**KIRKLEES METROPOLITAN COUNCIL
INVESTMENT & REGENERATION SERVICE**

Reference No:	2023/62/91983/W
Site Address:	12, Bayfield Close, Hade Edge, Holmfirth, HD9 2QX
Description:	Erection of first floor rear extension and associated alterations
Recommending Officer:	Tom Hunt

DECISION - REFUSED

Officer Report

**Drawing Title:**  
GA Plans & Elevations as Proposed

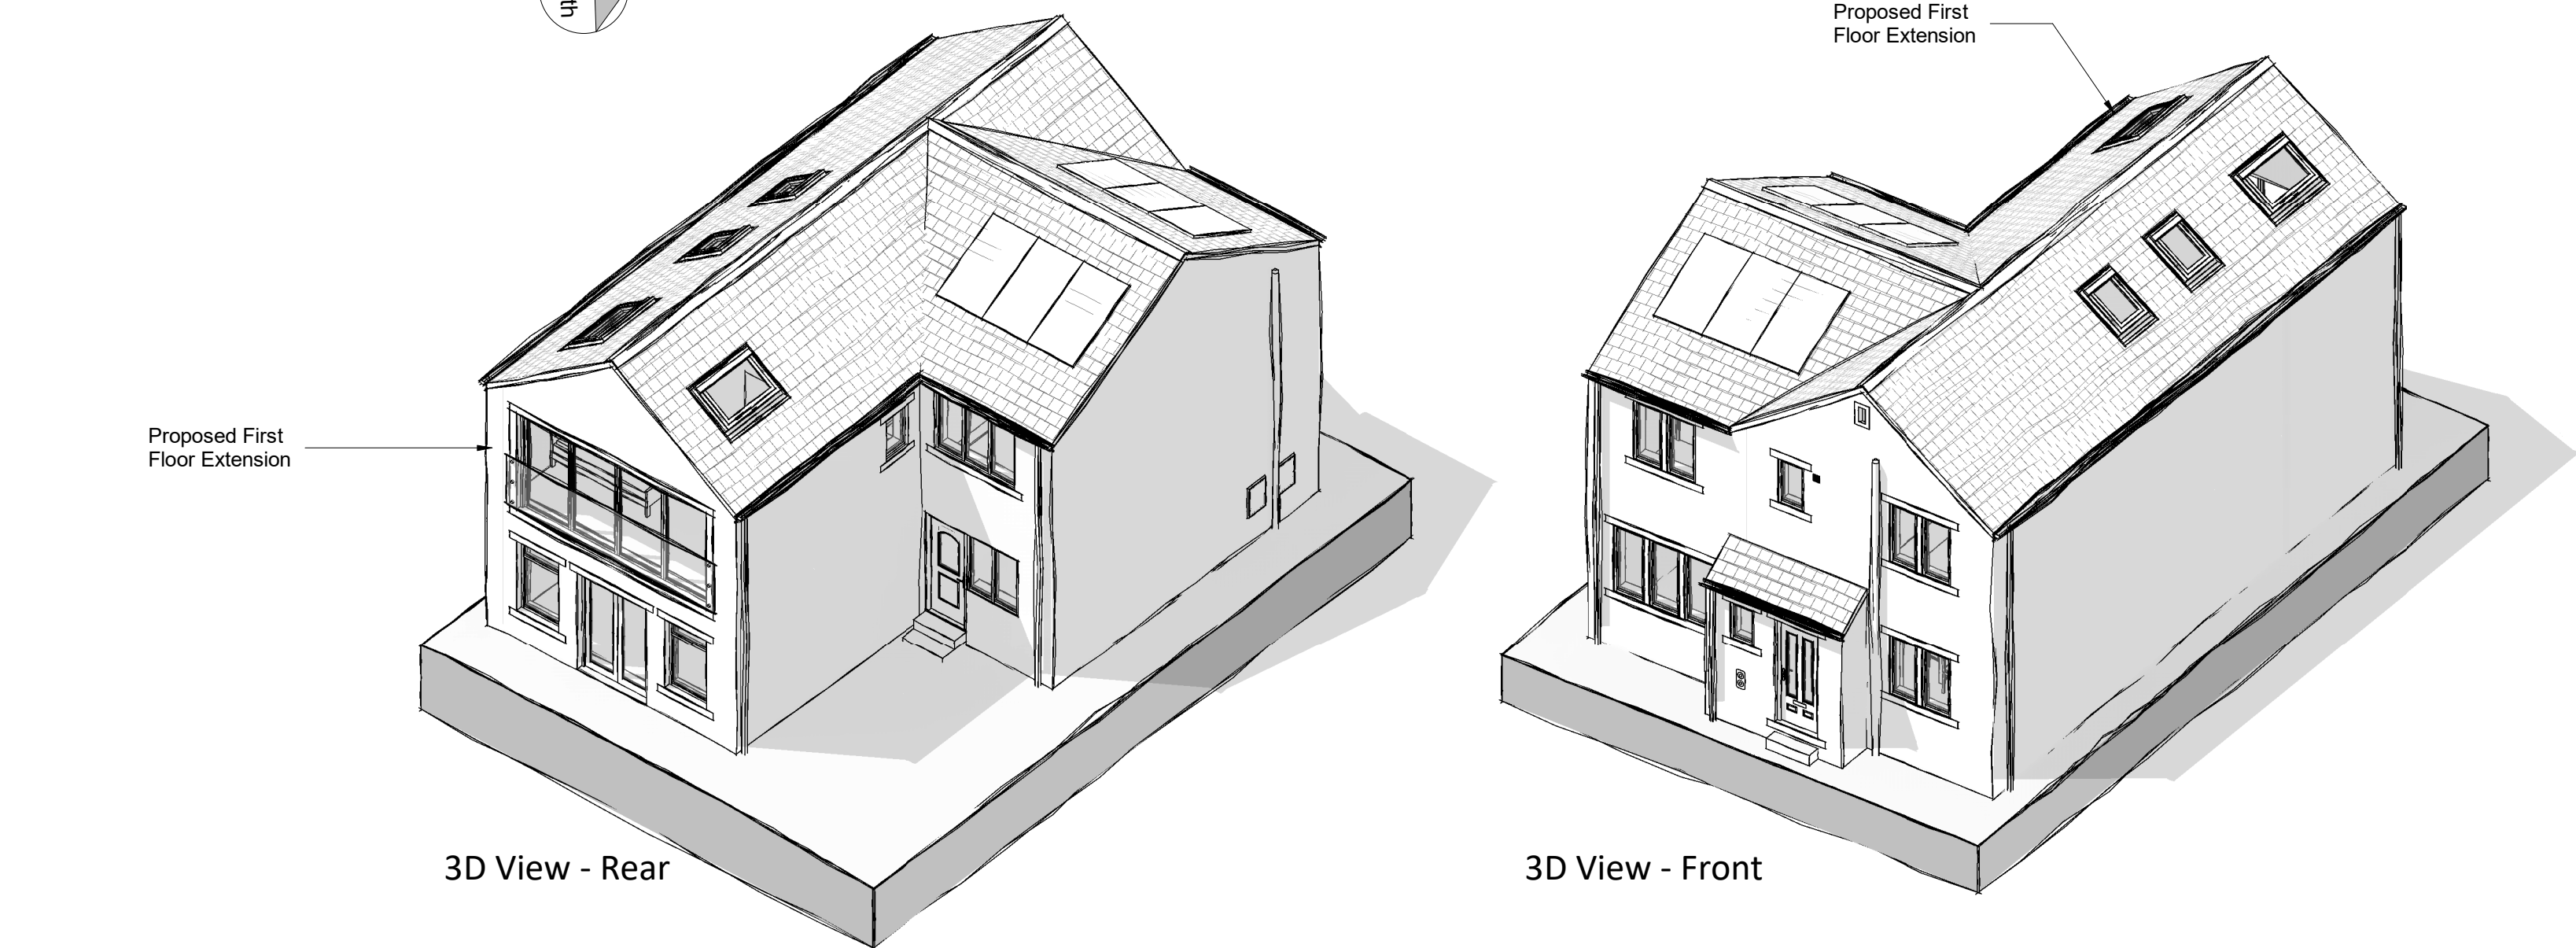
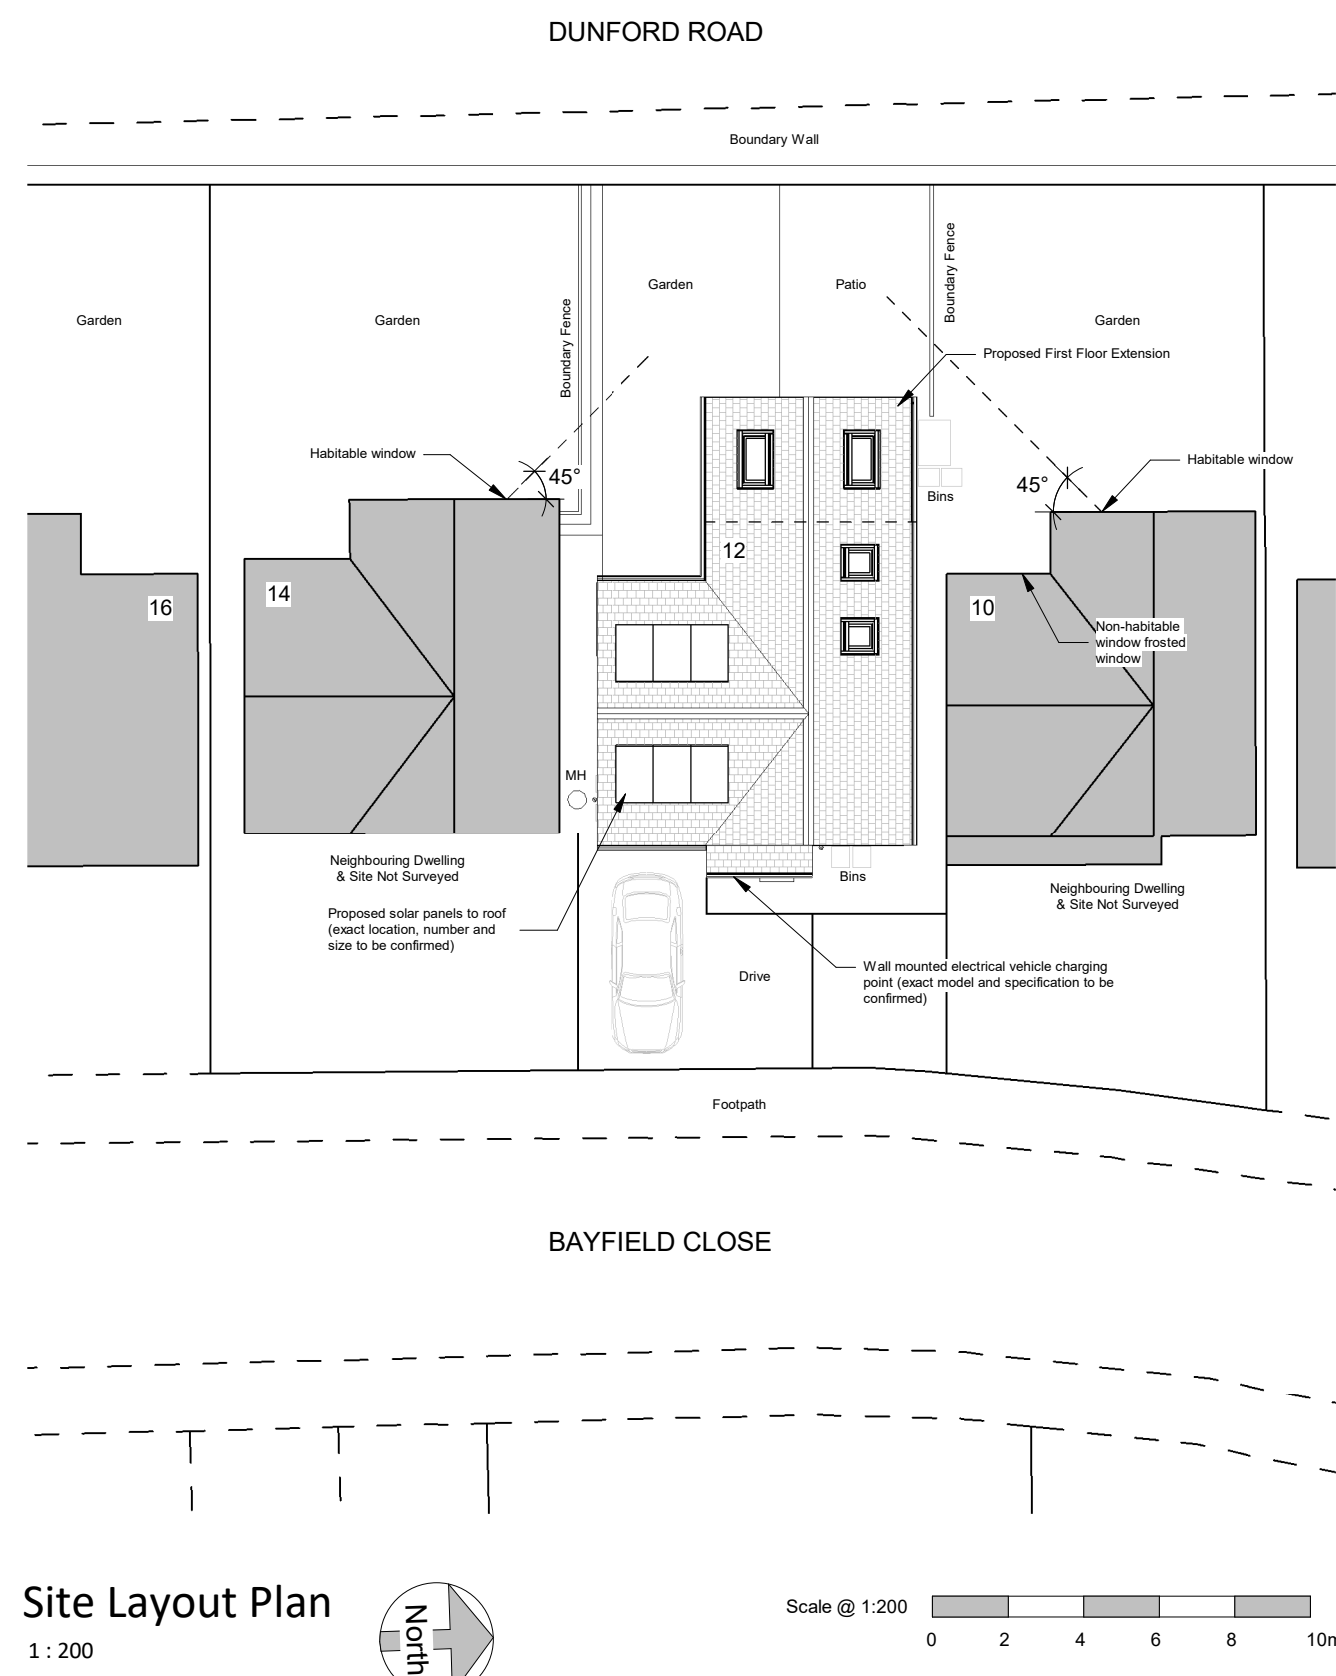
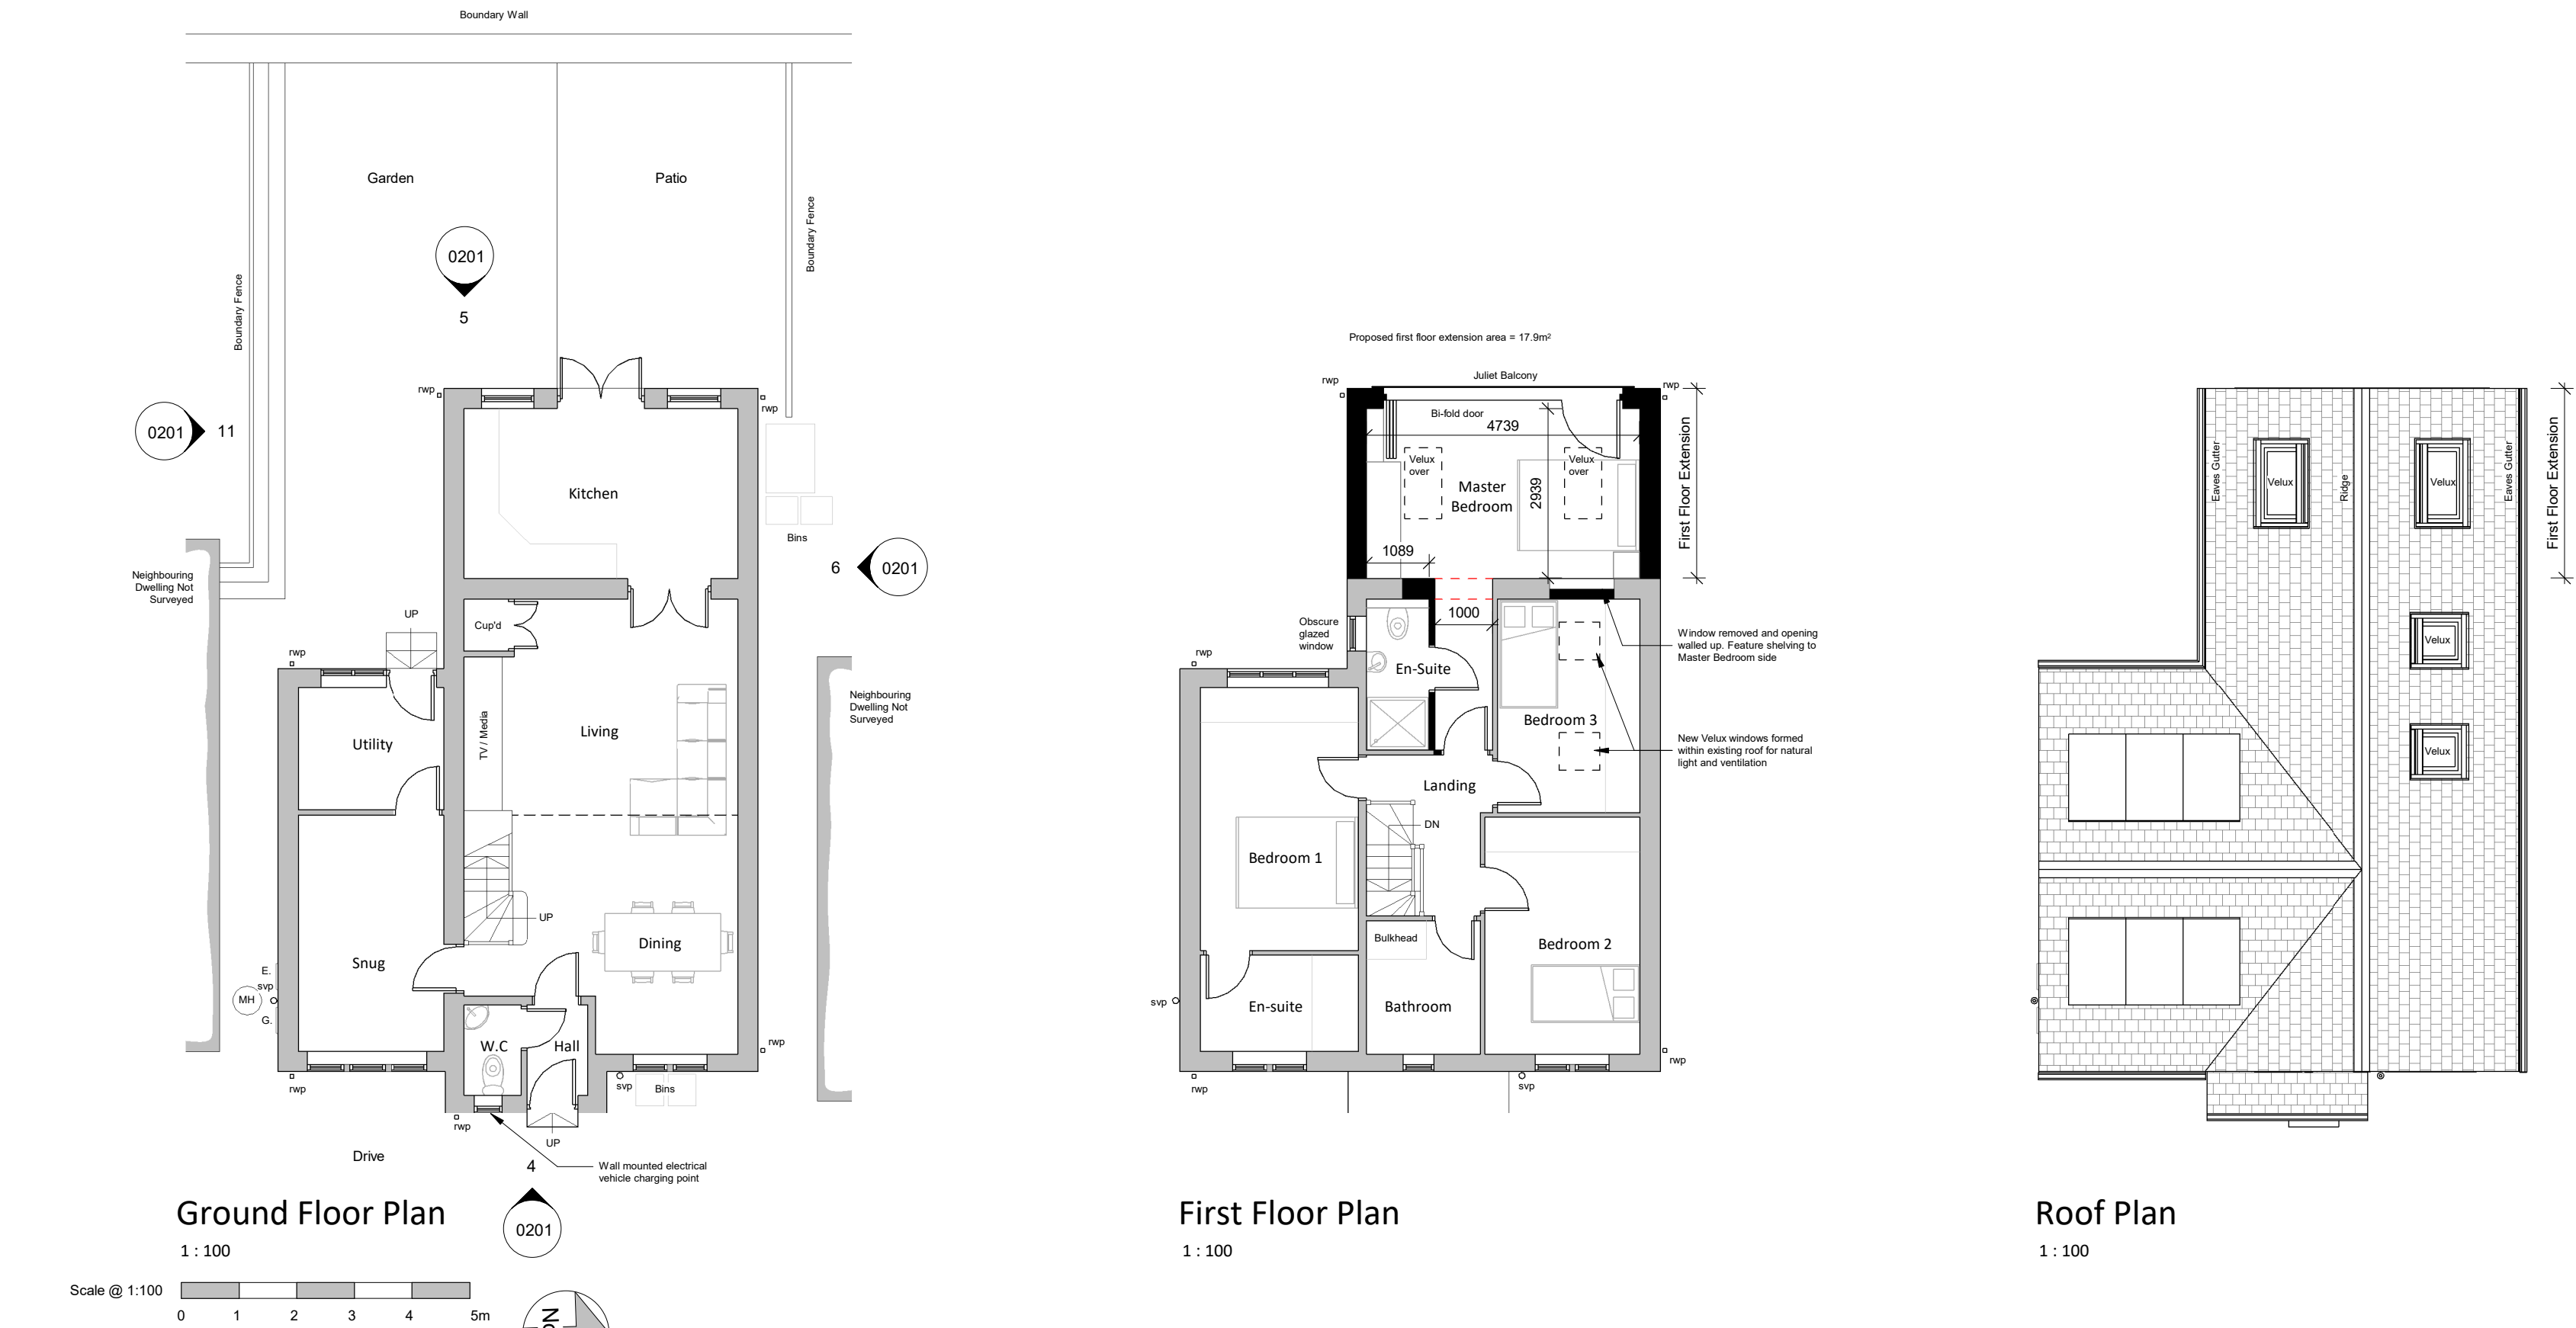
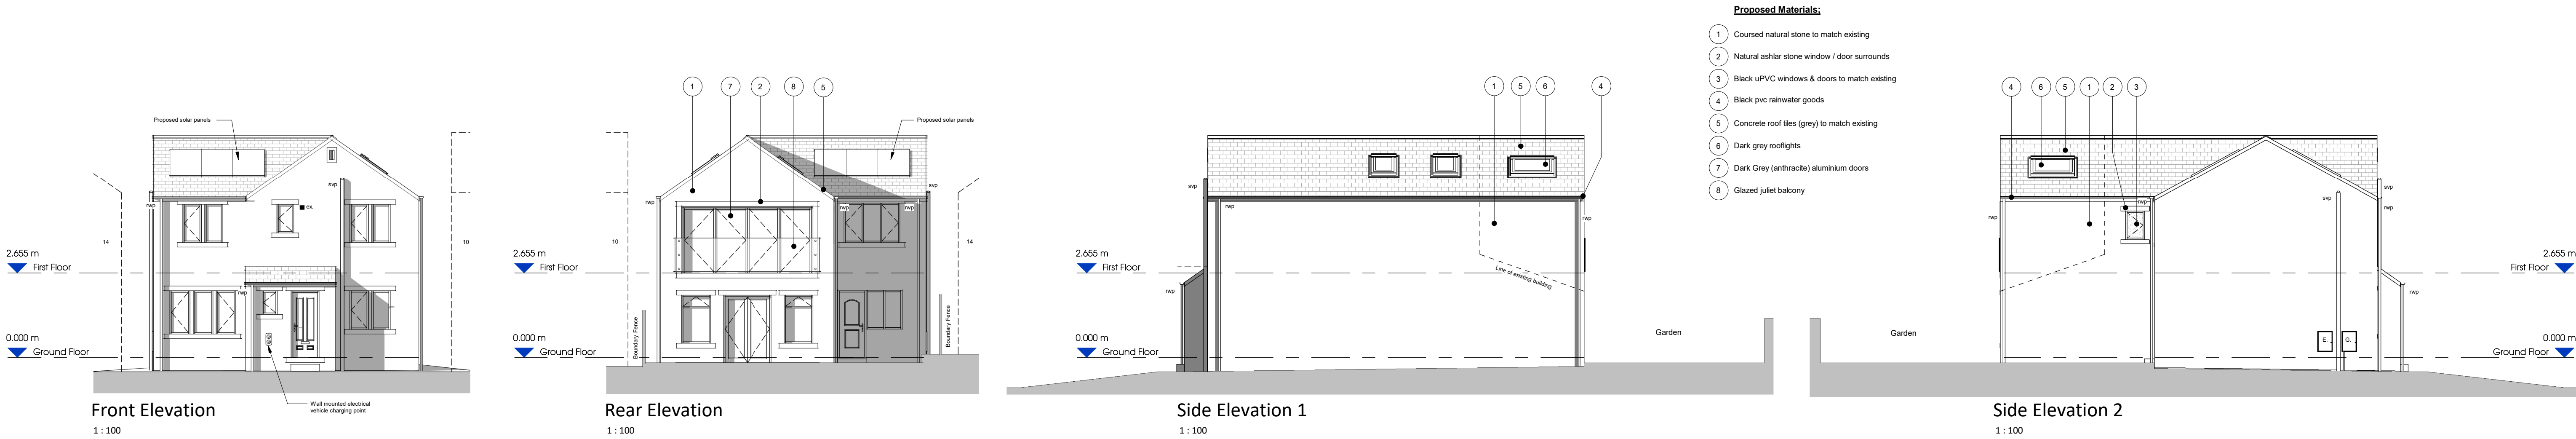
The proposal seeks to continue the design and form of the existing gable end from the rear, incorporating a similar roof style and pitch with its rear elevation finishing with the existing ground floor extension (3.3m projection from rear). It would not provide a clearance of 1.5m to flank boundaries and is above 3m to the eaves within 1.5m of the property boundary. It would be built over an existing footprint so there would be a neutral impact on the rear garden. Materials would be to match the host.

The glazing and Juliet balcony feature would appear as a somewhat incongruous and overly modern prominent design feature to the streetscene overlooking the recreation grounds with this effect made more visually jarring so close to the highway.

The 'rear' elevation of the dwelling addresses the main C-Class Dunford Road at close quarters and would be a dominant and incongruous feature in the street scene. It would be forward of the rear 'building line' of the dwellings on Bayfield Close and would introduce a more dominant, protruding gable feature prominent in the streetscape. It would appear noticeably larger than the more modest row of properties, and out of step with the scale of development locally. Furthermore, it would cumulatively add volume to a dwelling which has already been substantially altered and enlarged. Whilst the host has been much extended, this is presently seen in the context of similar extensions with its neighbouring properties and forms a pleasing consistency in architectural design. The extension would not be subservient and would over-dominate the original dwelling.

In conclusion, the proposed extension by reason of its siting, design, scale and massing taken cumulatively with existing extensions, would not be subservient to the original dwelling and would appear as an incongruous, overprominent and discordant addition to the dwelling and wider street scene.

The proposal would have a two-storey development approximately separated from the shared flank boundary by 3.3m and a new obscure glazed window to the first floor facing no. 14’s windowless side elevation. As such, it would be adequately sited at a distance to the north of the neighbour so as to avoid overbearing or any reduction in the 45° field of outlook from the windows at no. 14’s rear elevation, would not lead to overlooking or loss of privacy and overshadowing.

This property has a similar L shape configuration to no. 12 with a gable rear elevation set away ~3.6m from no. 12’s flank elevation. The proposed would have a very prominent two-storey development appearing 5.2m height from ground level separated 1m from no. 10’s flank elevation due southwest, and adjacent to no. 10’s kitchen window and obscure glazed en-suite windows. There would not be any additional windows to cause overlooking or loss of privacy. A 45° field of outlook has been sufficiently demonstrated for their habitable room window at the gable projection adequately avoiding overbearing effects to those. The adjacent windows are non-habitable and the kitchen window is already adjacent to the single-storey extension with its lean-to roof adding to a present minor closure of the field of outlook. Observation of the likely sun path throughout the year would have shadowing restricted to late afternoons to the rear elevation and not have a substantial impact on overshadowing. The outside amenity space used for sitting out and other activities is sited to the opposite side of the garden and therefore the proposal would have an acceptably limited impact on the amenity of the neighbours overall.

1. The proposed extension by reason of its siting, design, scale and massing taken cumulatively with existing extensions, would not be subservient to the original dwelling and would appear as an incongruous, overprominent and discordant addition to the dwelling and wider street scene. The development would be contrary to Policies LP2 and LP24(a) and (c) of the Kirklees Local Plan, Policies 1 & 2 of the Holme Valley Neighbourhood Development Plan, Key Design Principles 1 and 2 of the Kirklees House Extensions and Alterations Supplementary Planning Document and Policy set out in Chapter 12 of the National Planning Policy Framework.
